Griffith Avenue and Districts Residents Association

MetroLink Oral Hearing Submission

22/02/2024

ALBERT COLLEGE PARK INTERVENTION SHAFT. PLAN
SCALE 1:400

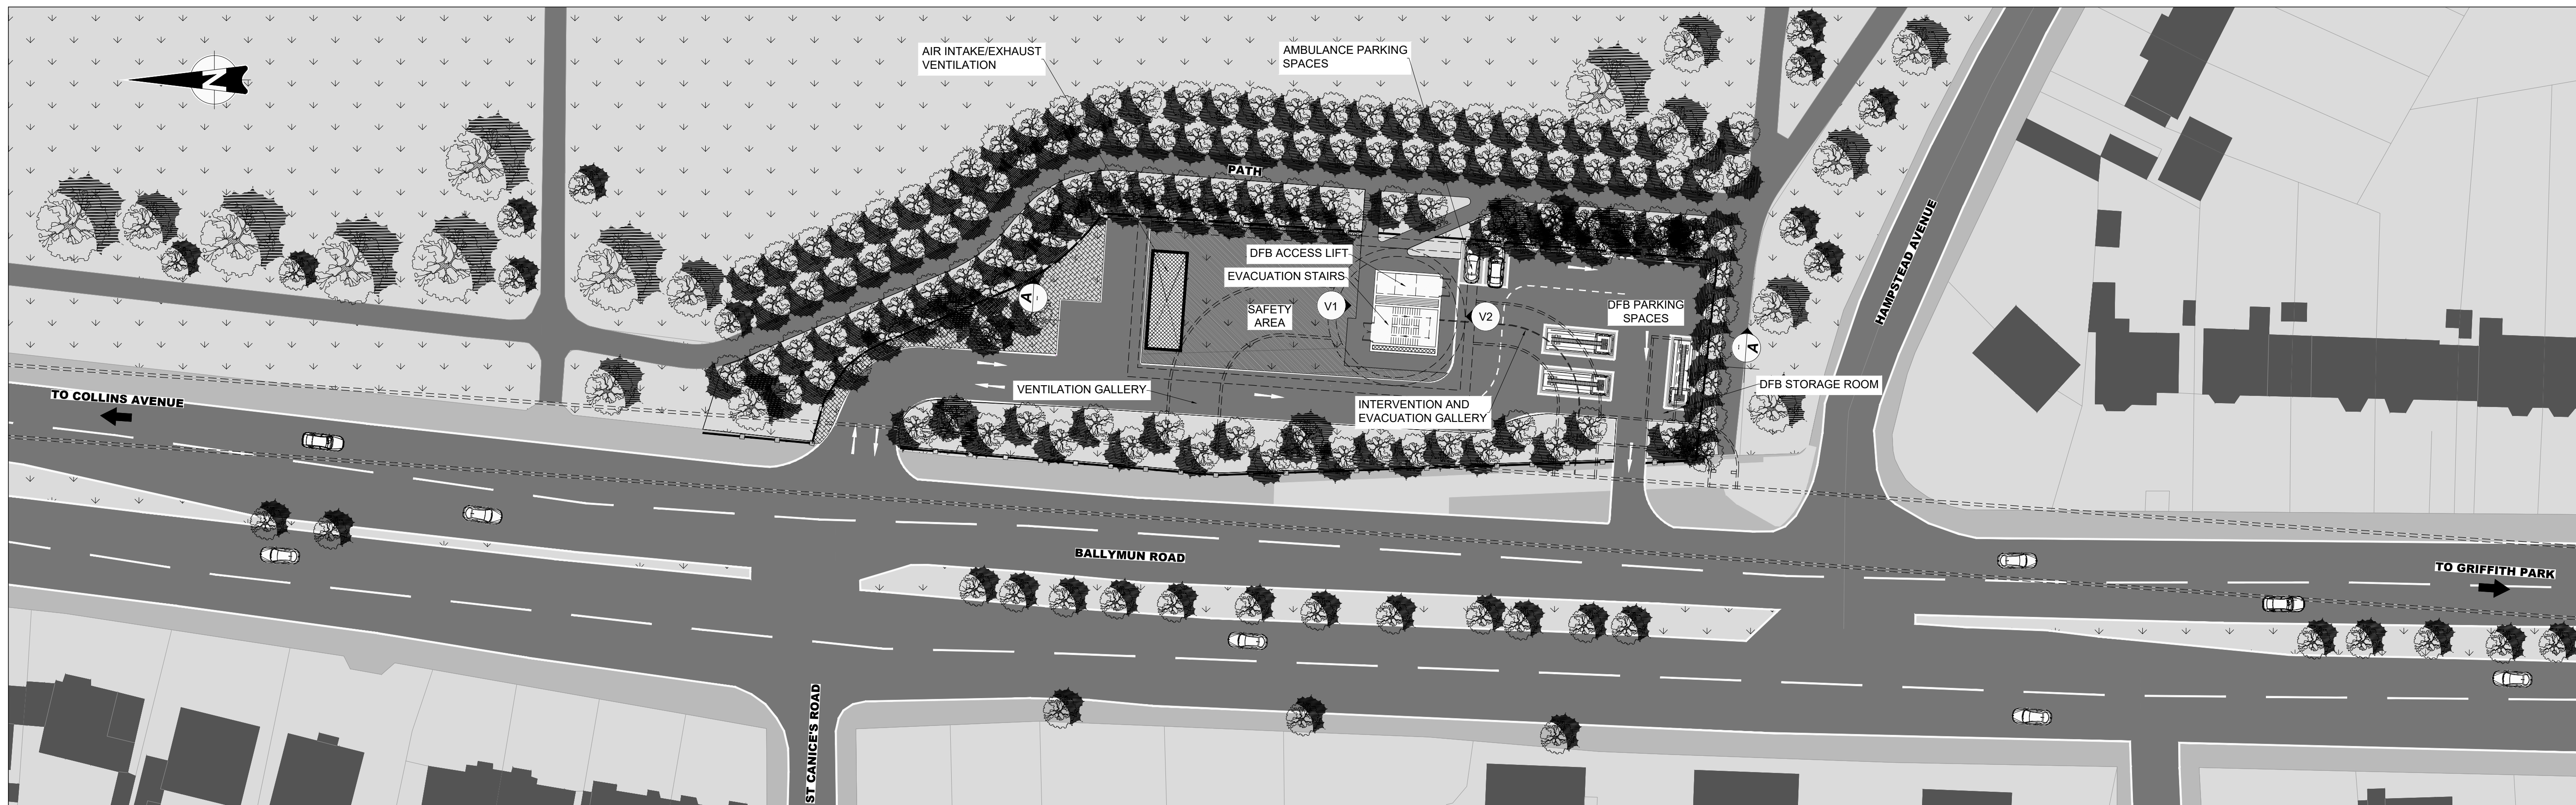
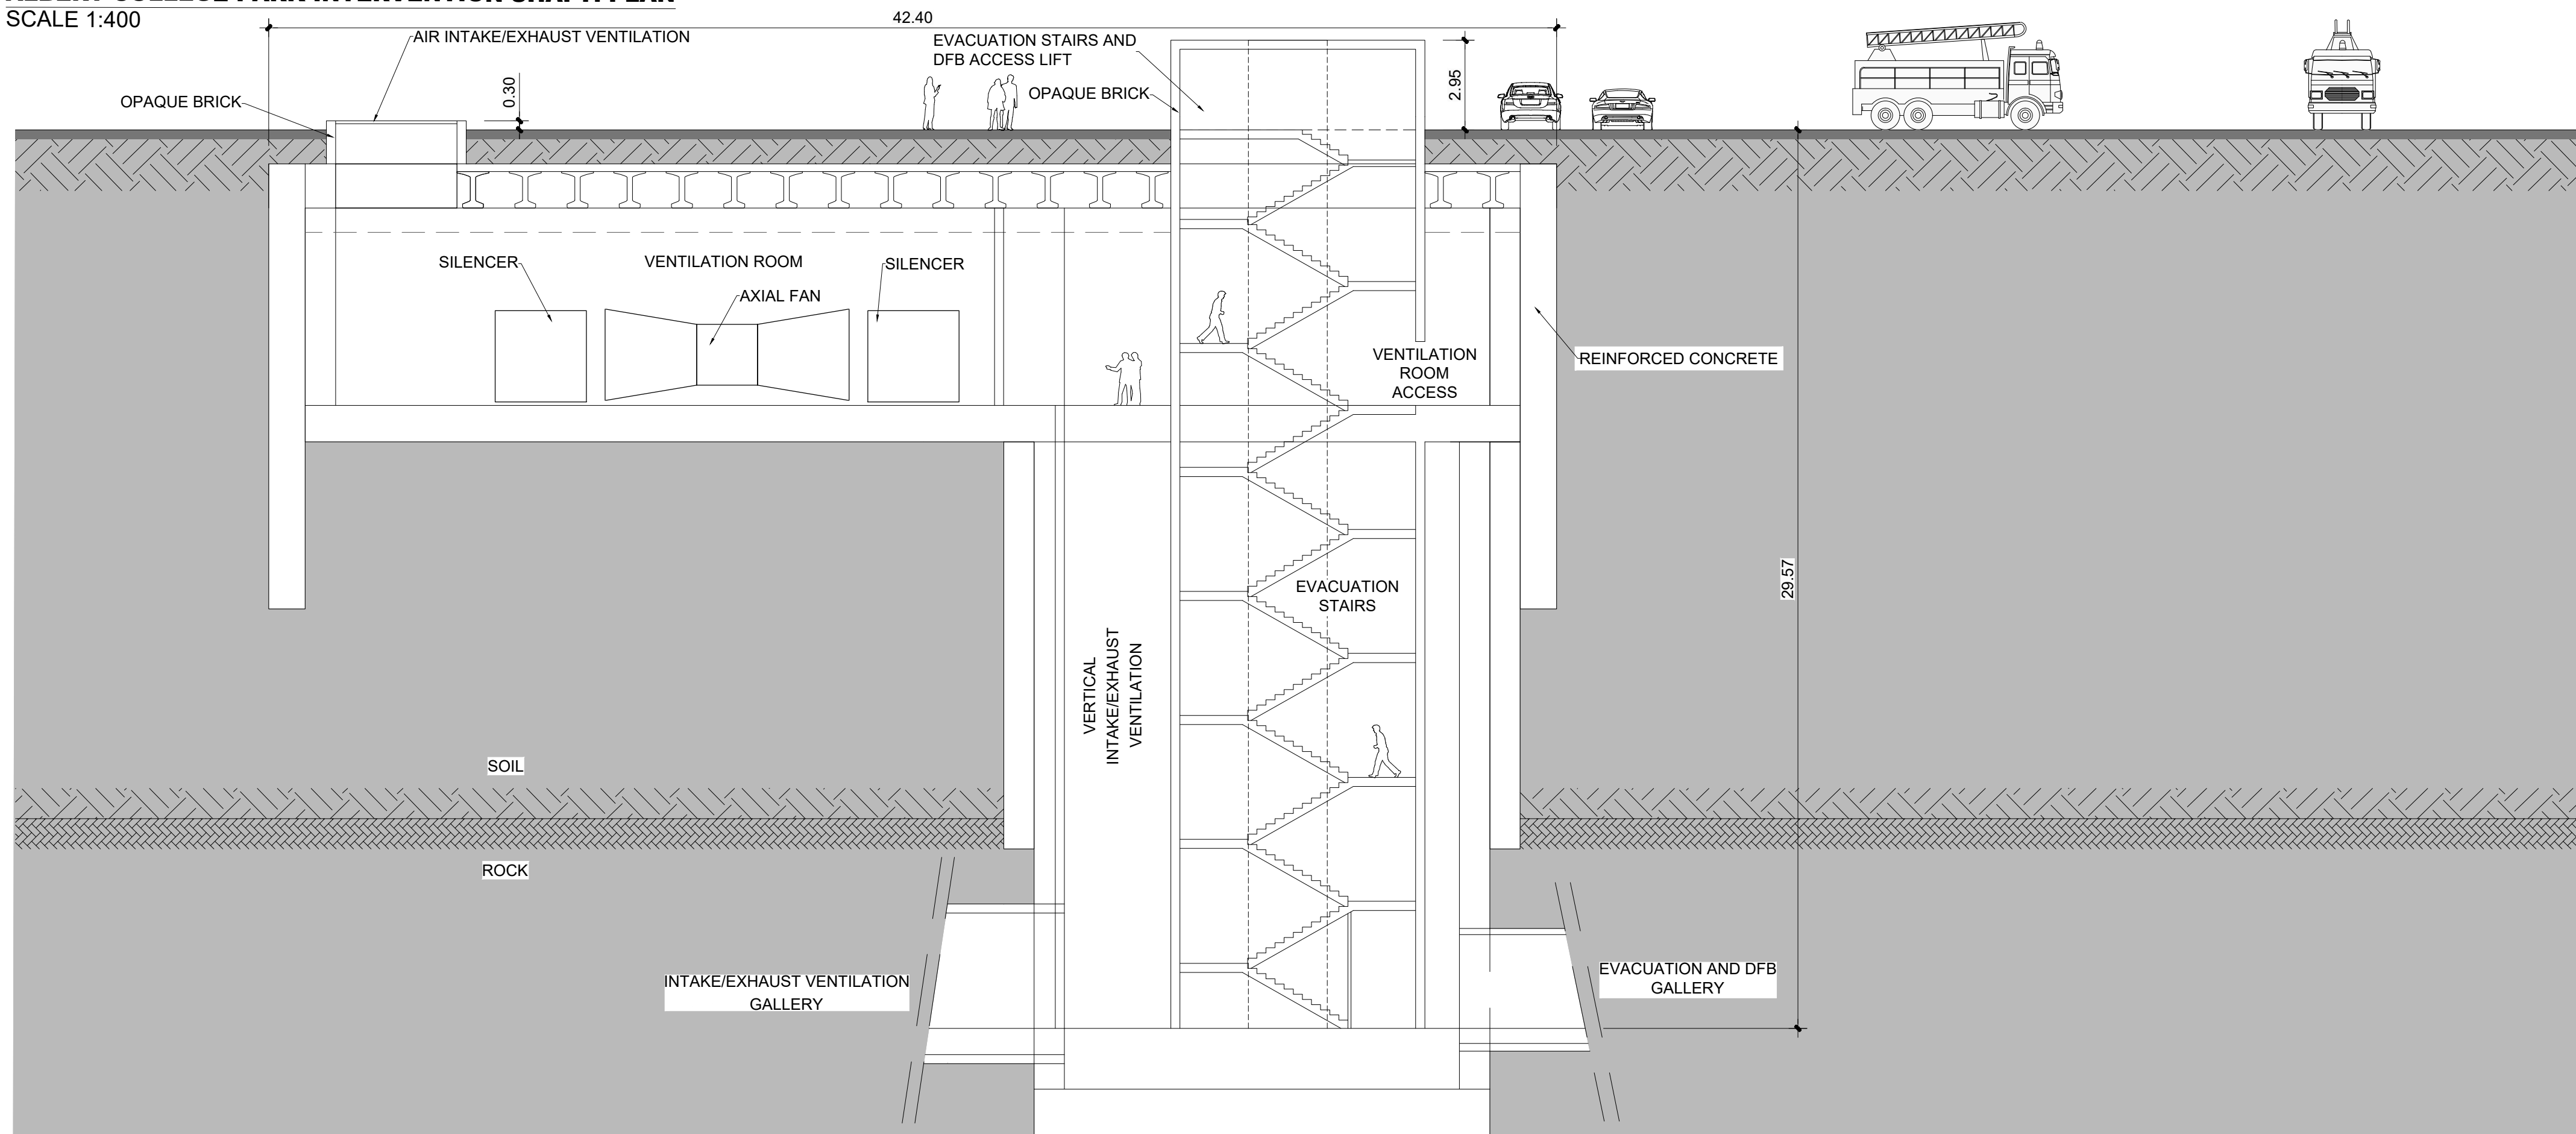
3. In item 11, the NTA state that the large construction compound around the Intervention Shaft is required for emergency vehicles and congregating passengers.

The Independent Experts have informed us that custom and practice in Metro's worldwide prove that this is not the case. This shaft will be in a park – the evacuating passengers will be able to congregate safely within the park without there being any need for an extended car park. Indeed, we know that many DFB approved fire evacuation plans for large office buildings in Dublin City Centre incorporate local parks for this purpose, so there is absolutely no justification for not doing so in this case – especially as no public roads have to be crossed to access a safe congregation space. This would negate the NTAs assertion that the large area around the intervention shaft is required for congregating passengers.

RINA have informed us of international standards and best practice and, having looked at the alignment drawings, we made a proposal into the RO application that the layby into the side reservation of Ballymun Road is created and marked for fire and emergency vehicles. The layby could fall within 20 metres of the entrance of the shaft and thus would meet DFB's requirements. This would enable all the parking for emergency vehicles to be outside the park boundaries, with a single large double gate facing the layby. This is an option that would negate the NTAs assertion that the large area around the intervention shaft is required for emergency vehicles.

Considering all of the above, it seems to us that the purpose of the large footprint allowed for at this site is to facilitate space for maintenance vehicles. In our opinion, this is not an acceptable use of a public park, especially, where there are other options. Opportunities are never going to arise to increase the city parks in our area. We do not see it as appropriate to give precious park land including pitches, away in exchange for a sterile car park for maintenance vehicles. We believe these maintenance vehicles could be housed in a location which is not as widely used and valued as a public amenity.

As part of our ongoing engagements with the Independent Experts, GADRA queried whether they were aware of any Intervention Shaft designs globally that required the scale of footprint that is being considered here. RINA indicated that they had seen intervention shafts of considerable scale but noted that they had not previously come across an Intervention Shaft in a park – shafts tend to be incorporated into buildings or as free-standing structures within the built environment.

All of the above points lead GADRA to question how NTA can stand over their statement that the current large area around the Intervention Shaft is required for emergency vehicles and congregating passengers.
